Your ref: SSD 9063
File no: MC-18-00001

Re: SSD 9063 - Tallawong Station Precinct South (formerly known as Cudgegong Road Station South) - 69-79 Schofields Road, Rouse Hill

ATTACHMENT A

Figure 4: Plan looking west showing small areas of buildings above 26m height limit

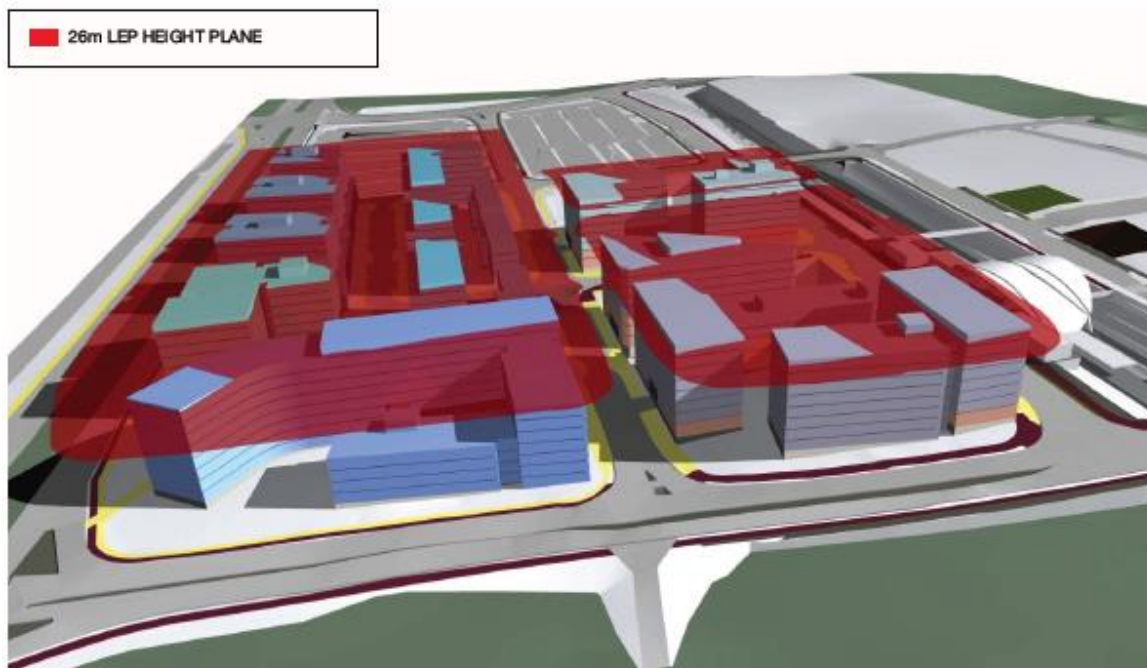
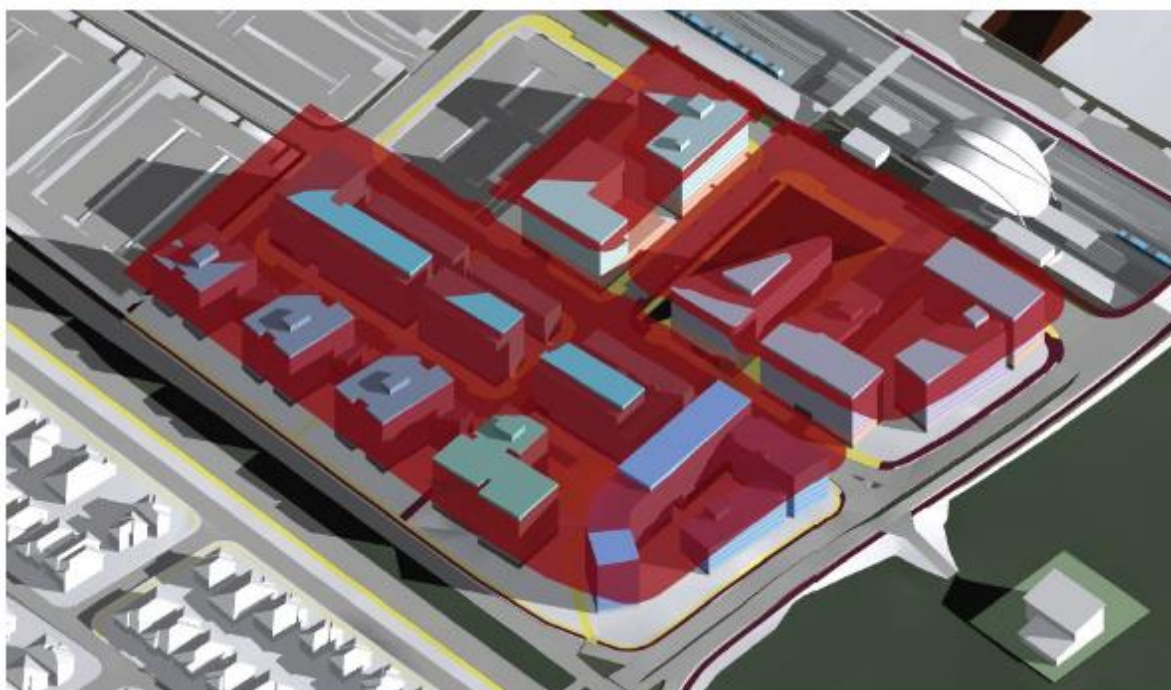
1. The site has a 26 m height limit, therefore a maximum of 8 storeys is permitted. There should be no residential units above the 26 m height limit with the exception normally given to lift overruns, parapets and lightweight roof structures associated with rooftop communal open space. Lift overruns and shade structures should be integrated into a singular cohesive element. The only departure where we might normally consider a residential height encroachment above the height standard is where one part of the development is under the designated height limit and is appropriately offset elsewhere on the site. We are unable to determine whether appropriate offsets have been provided and need to see detailed calculations.

DETAILED URBAN PLAN AND SECTION A

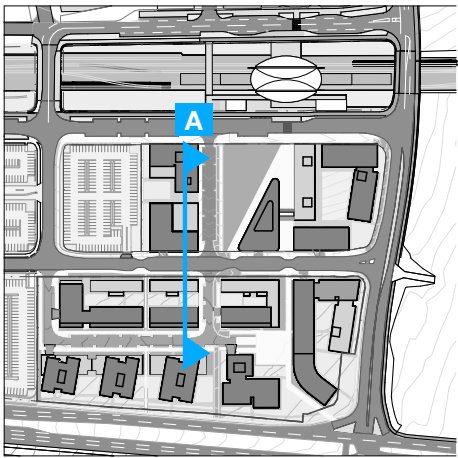
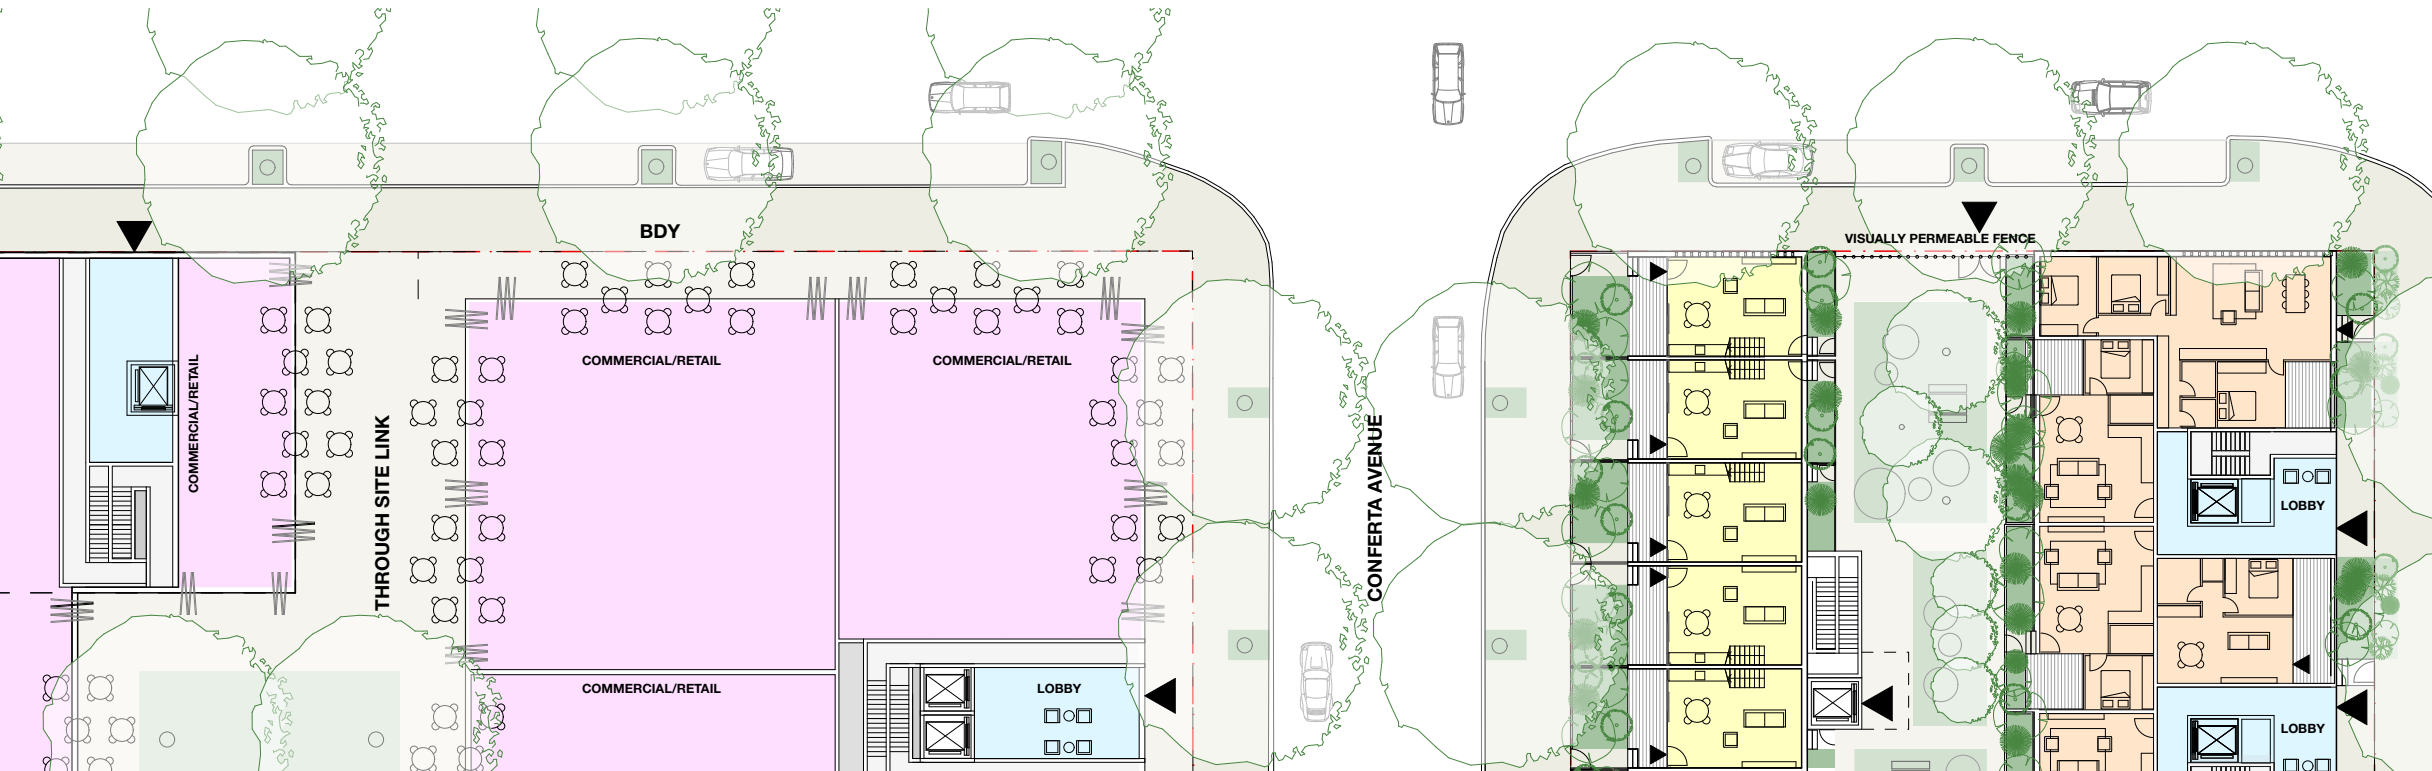
3. A single basement entry to each lot is required.
4. The ground floor residential interface can be up to 1 m above the footpath level, not 450 mm as noted on the detailed urban plan and section A.
